**Subject: EnergyConnect (NSW - Western Section) – SSI 10040**

Thank you for your email dated 27 October 2020 seeking comments from the Biodiversity and Conservation Division (BCD) of the Department of Planning, Industry and Environment (the Department) on the Environmental Impact Statement (EIS) for the EnergyConnect (Western Section) project (SSI 10040).

## ATTACHMENT A BCD Assessment Summary for EnergyConnect (NSW – Western Section) Environmental Impact Statement (SSD 10040)

## **ATTACHMENT B Detailed comments for EnergyConnect (NSW - Western Section) Environmental Impact Statement (SSI 10040)**

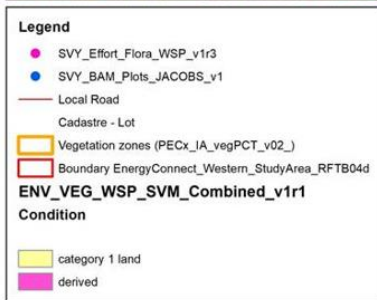
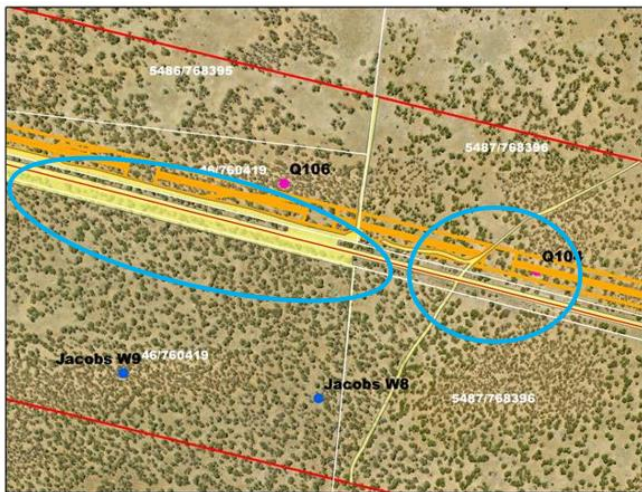
Areas of vegetation labelled as 'no impact' in the digital data (PECx\_IA\_vegPVT\_v02) where maintenance activities may occur have not been assessed.

Some areas of naturally treeless vegetation have not been assessed. Assumptions about the impact of maintenance on biodiversity are not sufficiently explained to justify exclusion of these areas from the assessment.

For example: South Olary Plain sub-region (Lot 9, DP 1255309), mapped as PCT 154 Pearl Bluebush low open-shrubland in the vicinity of Jacobs flora plot W12. Jacobs ecologists described vegetation within this plot as in 'good condition'.

- the specific impacts of maintenance
- if maintenance includes regular vehicle movements across the vegetation
- if weed control is to occur within this area, and if so, what are the impacts on this vegetation and associated threatened species and their habitats?

- *Include areas where maintenance actions will occur in the impact area for the project or justify why ongoing maintenance activities will have **no** impact on biodiversity.*

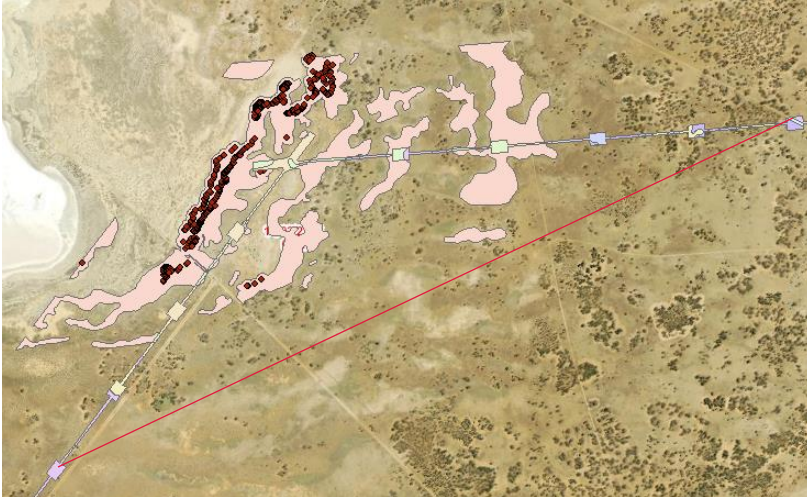
However, the BDAR states that the proposal was refined to avoid and minimise impacts on *Austrostipa nullanulla*. In fact, there is an opportunity to completely avoid the gypseous rises that are habitat for this species by running the alignment south of this area (see figure below). The EIS does not explain why this option was not feasible.

- Explain why the project alignment cannot avoid the areas of habitat for *Austrostipa nullanulla*.

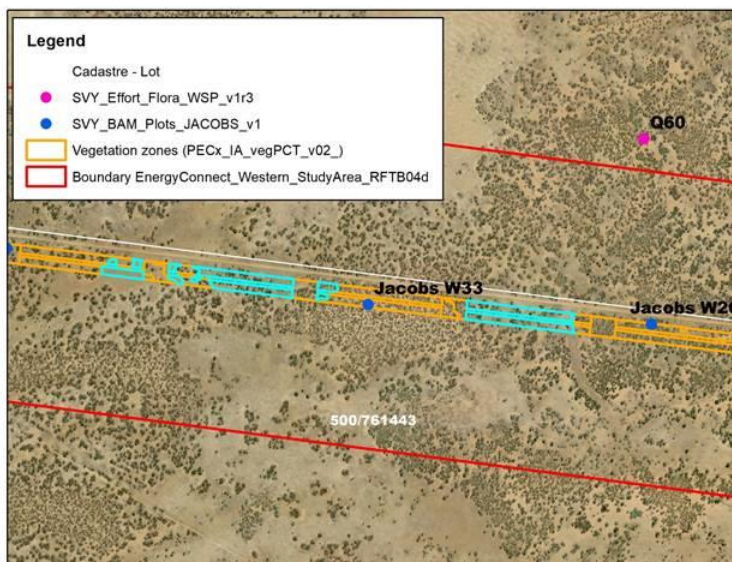
11.	<i>Issue</i>	<p>Derived native vegetation communities appear to have been over-estimated.</p> <p><b>Recommended action:</b></p> <ul style="list-style-type: none"> <li>Demonstrate that vegetation mapped as derived is not an open-woodland or natural structural variant of the relevant PCT, such as where the overstorey is absent due to fire or drought.</li> </ul>
	<i>Extent and Timing</i>	Pre-determination
